Addendum to Plan of 52 Federal St. Portland, ME dated 2/6/2012 and received 2/7/2012

Address: 52 Federal St. Portland, ME

Applicant/ owner: Liv Chase and Brent Adler

The following corrections are to be noted in relation to the applicants submittal for building permit received February 7, 2012:

Rev.	A	B	C
Date	09-13-11	10-13-11	01-23-12
Remark	Issued for pricing	Issued for Permitting	RE-issued for Permitting
CODE:	IBC 2009		
TOWN:	Portland		
DATE:	09-13-11		
SCALE:	as noted		
DESIGNED:	LJC		
DRAWN:	JJC		
TITLE:	Third Floor Plan Schedules		
FILE:	A1.04		
SHEET:	A1.04

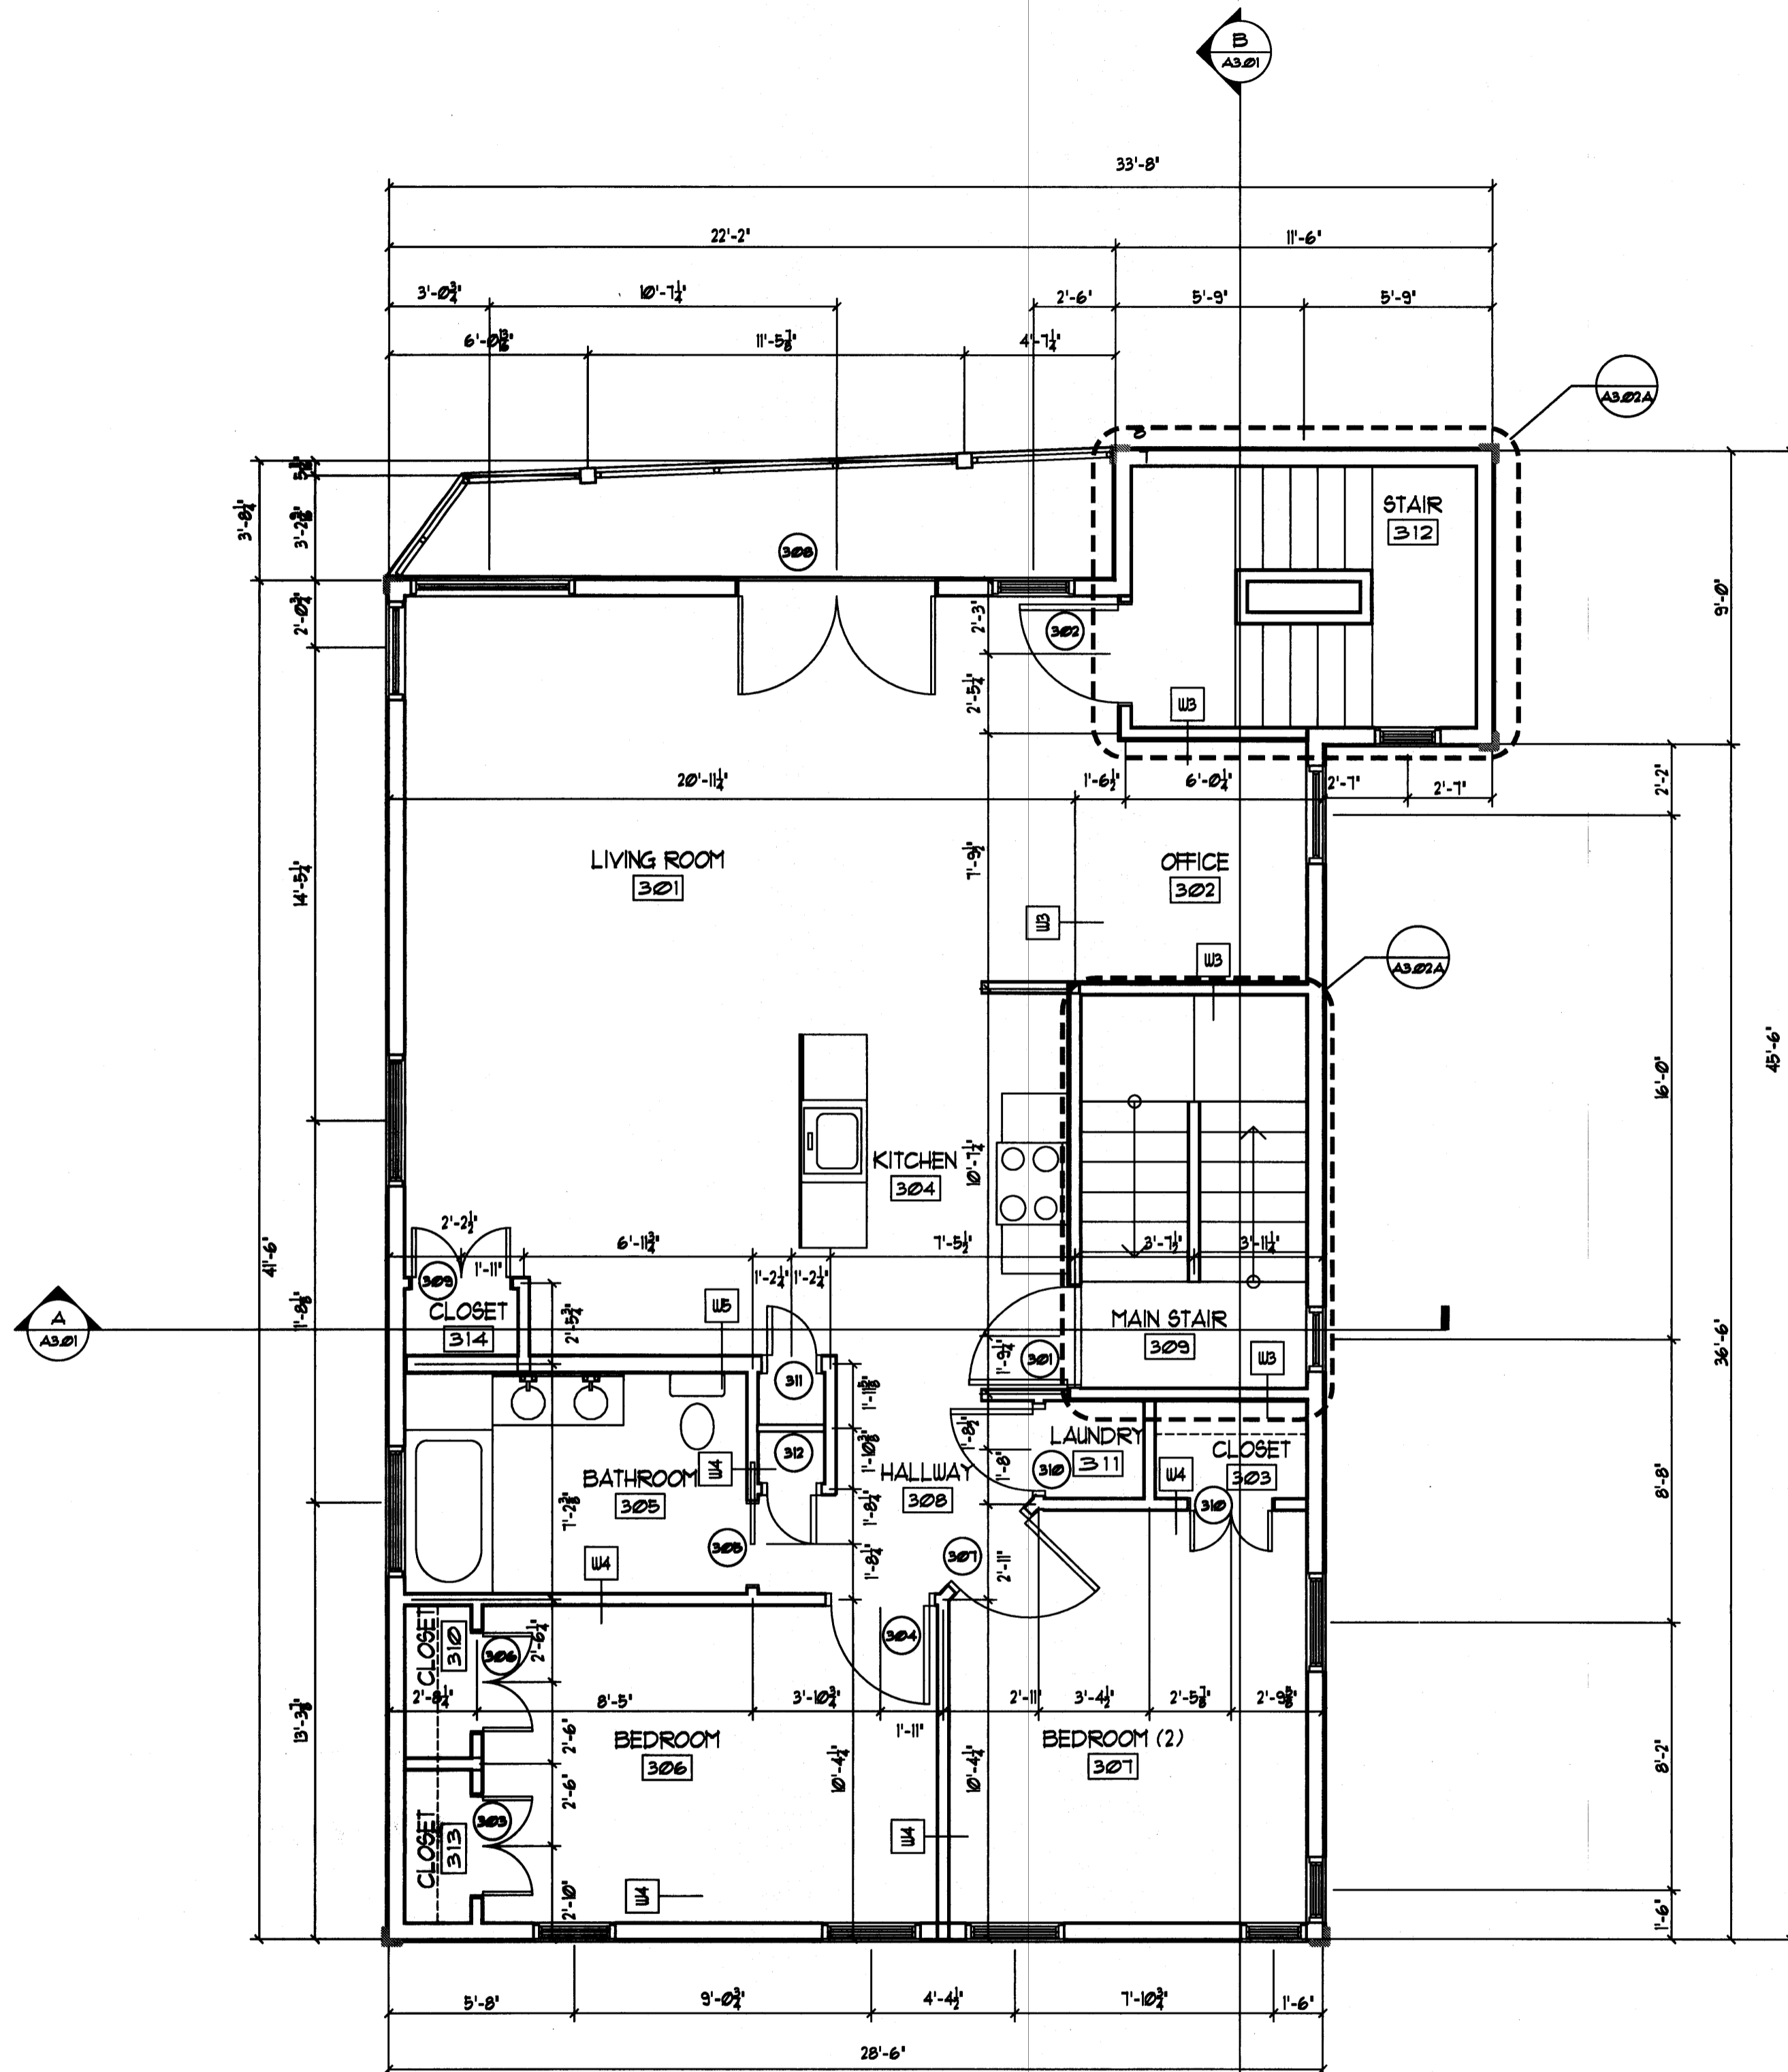
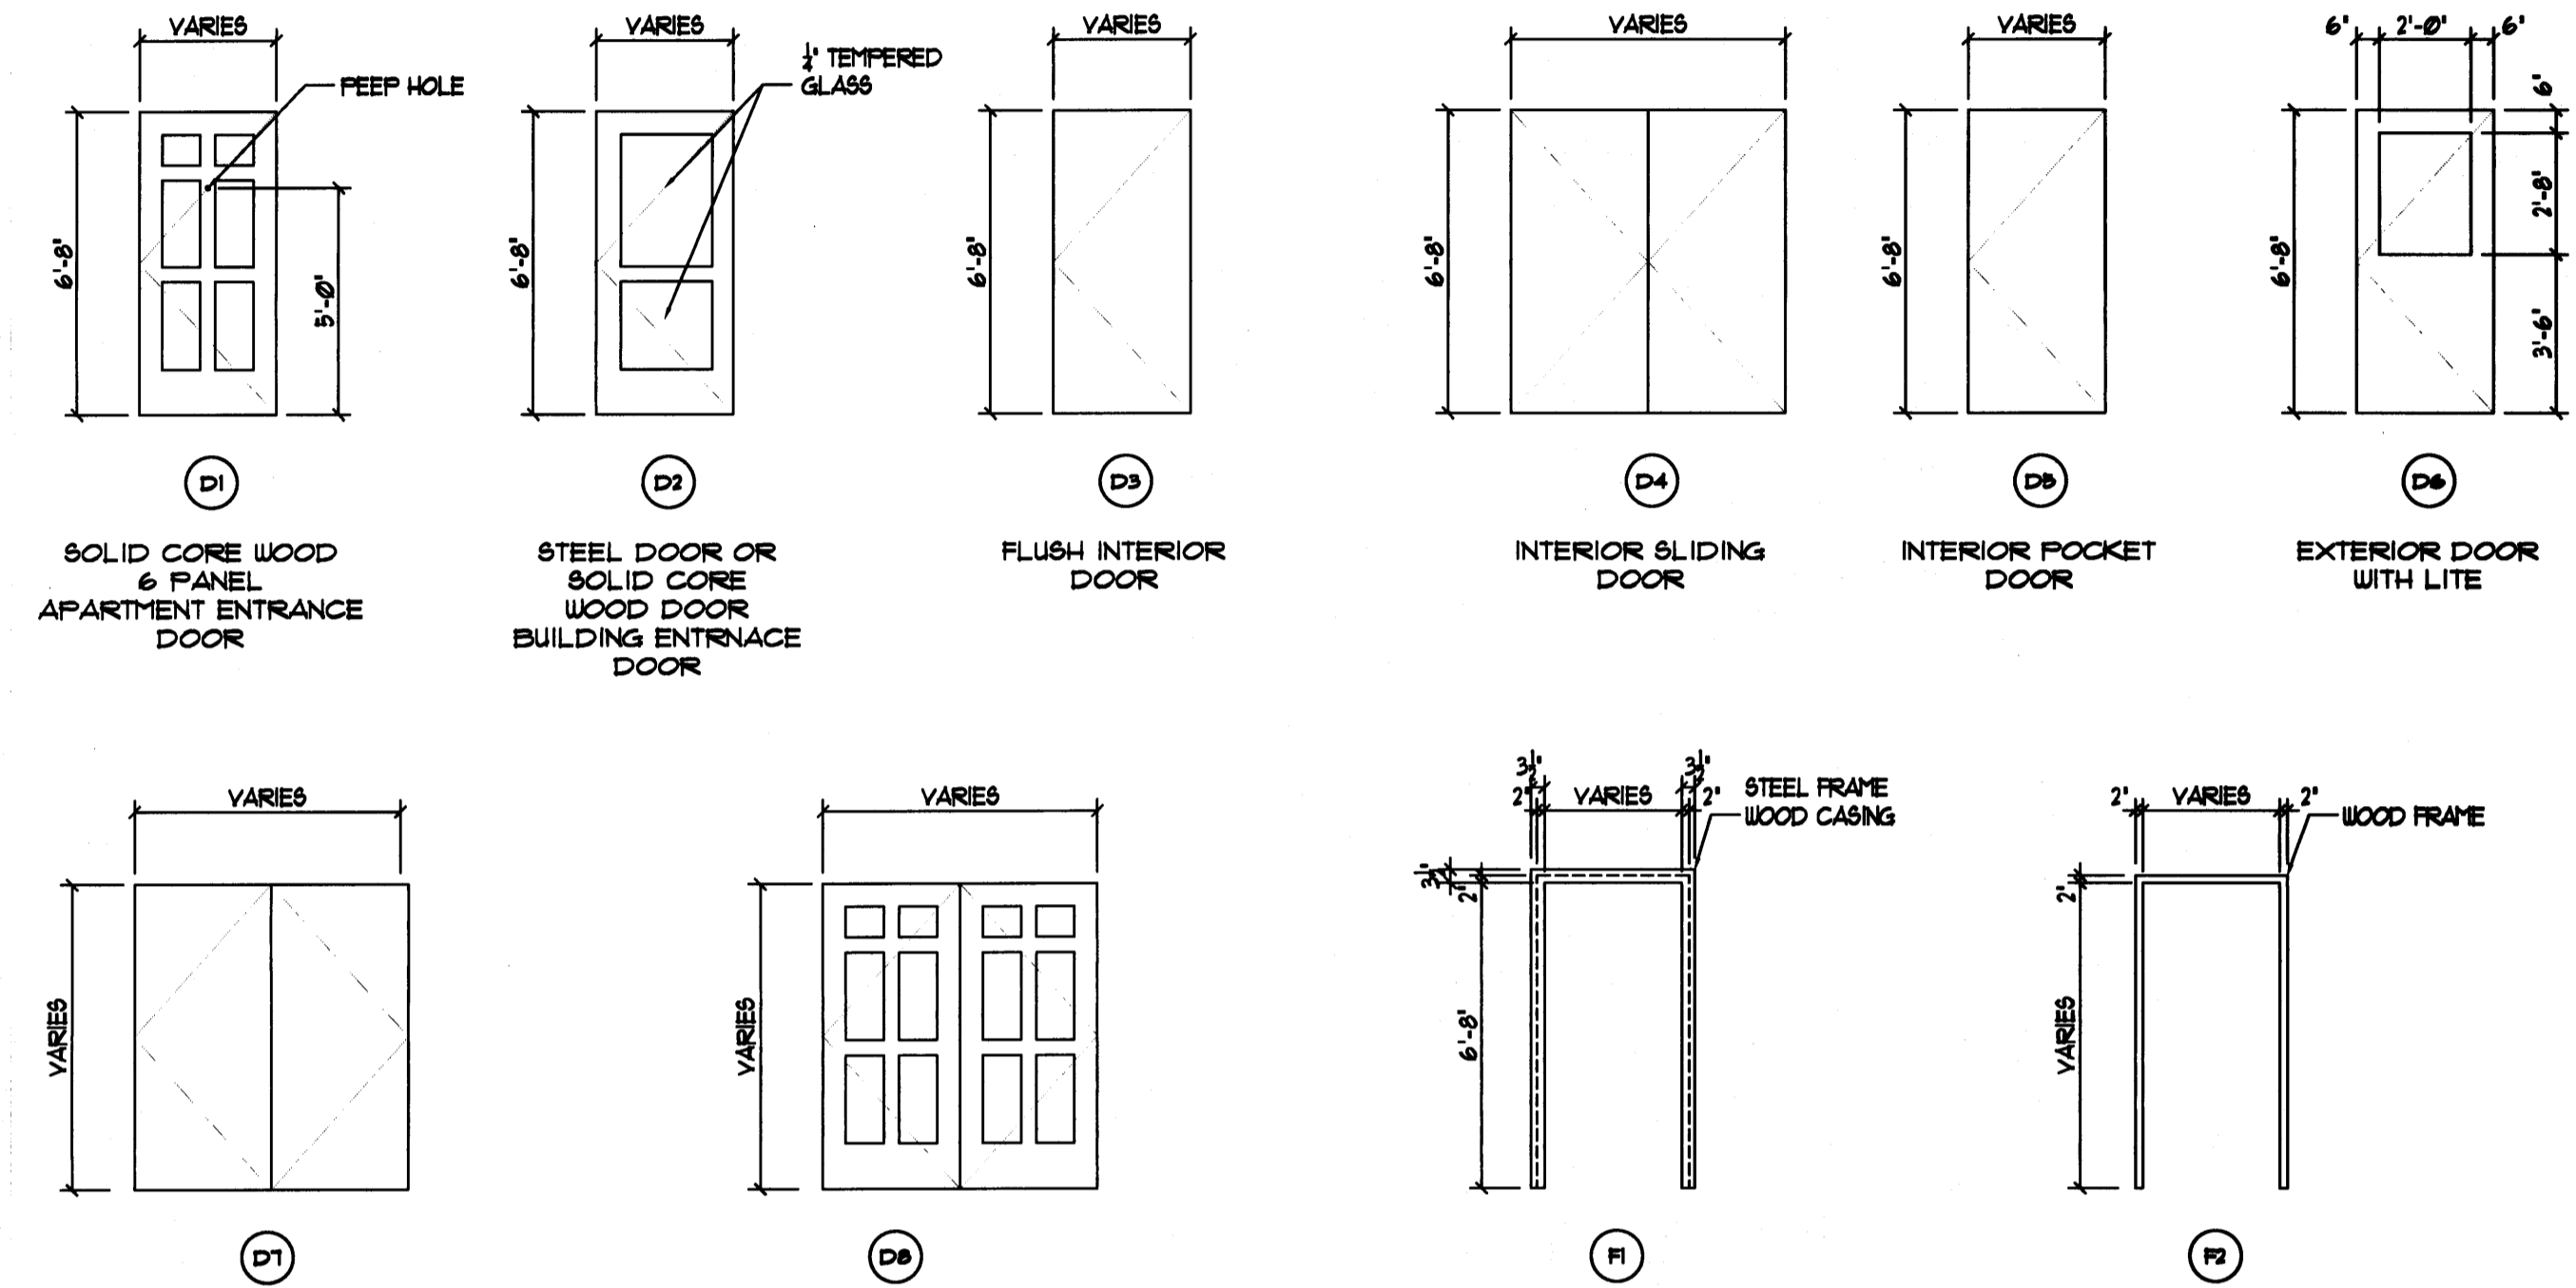
4. 3rd floor Plan Schedules Sheet A1.04
 - Rear staircase ends at 4th floor.
5. Wall Type Sheet A3.04
 - W3 wall assembly to be 2 hour fire rated not 1 hour rated

CODE: IBC  
 TOWN: Portland  
 DATE: 09-13-11  
 SCALE: as noted  
 DESIGNED: LC  
 DRAWN: JJD  
 TITLE: SECTIONS  
 FILE:  
 SHEET: A3.01

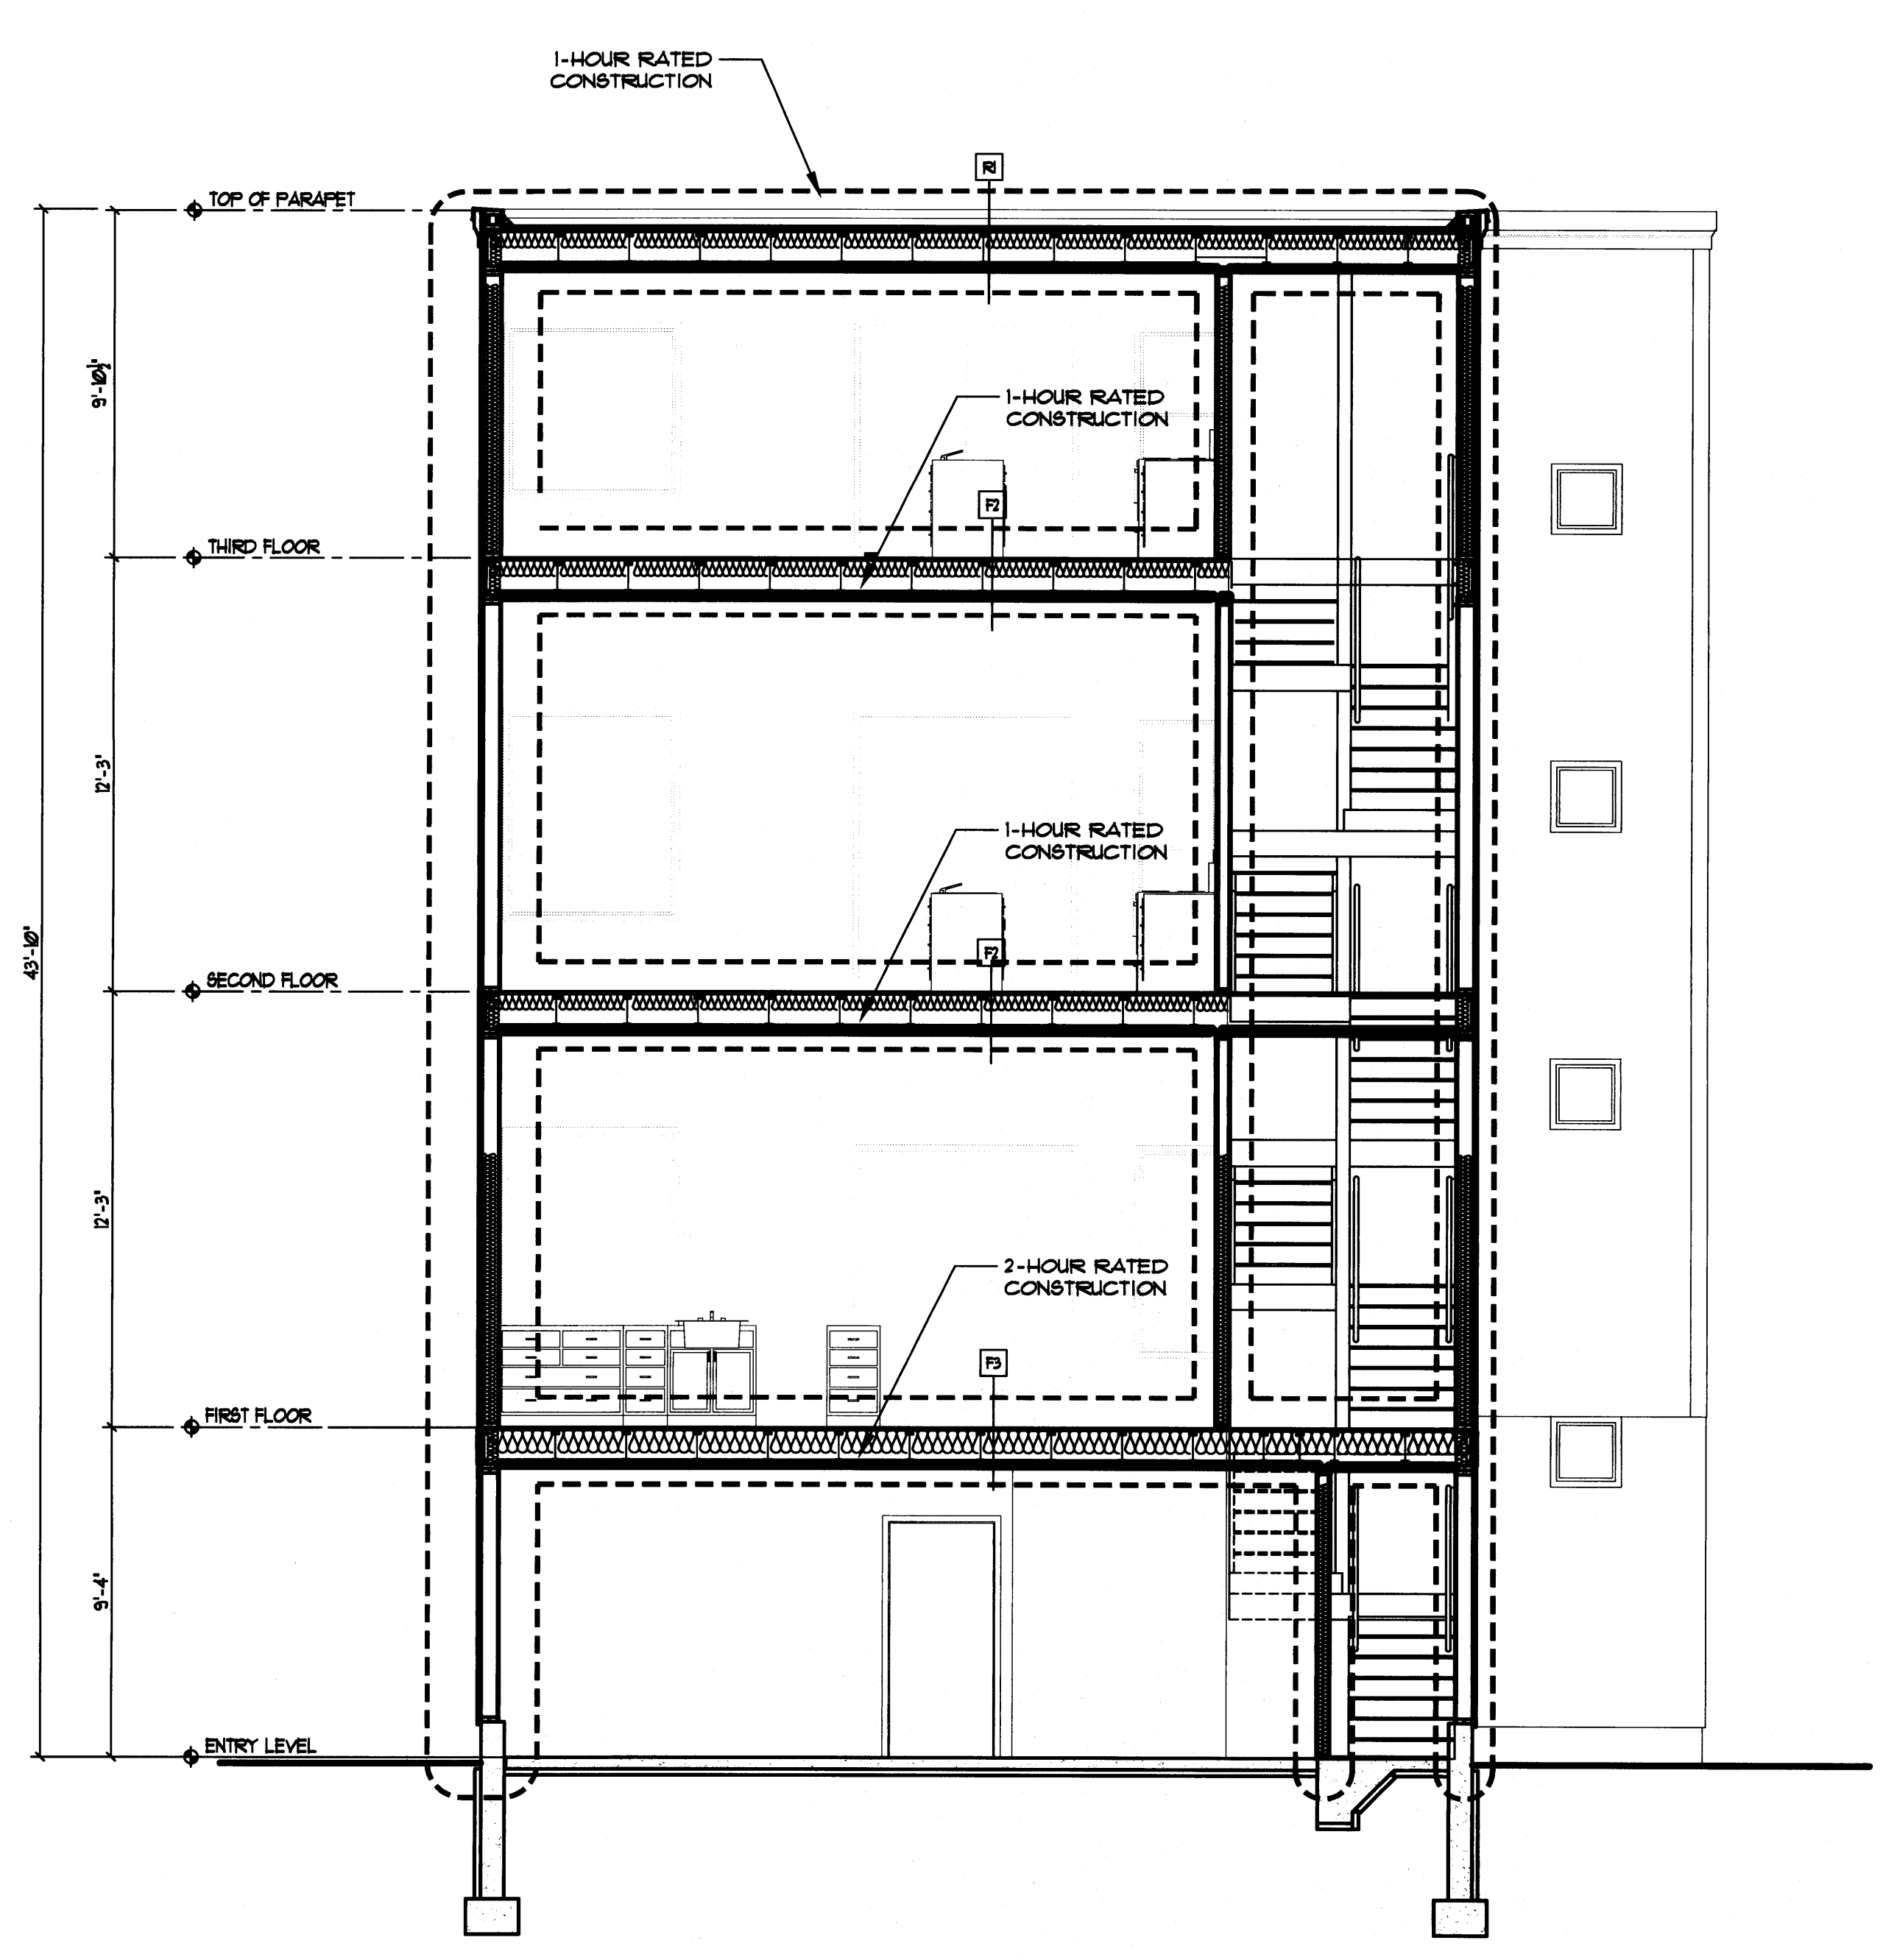
- Main stairwell wall to be 2 hour wall assembly
3. Sections Sheet A3.01
 - The roof above both stair towers is 1 hour rated construction
 - Roof access design to be submitted after permit is issued (see below)
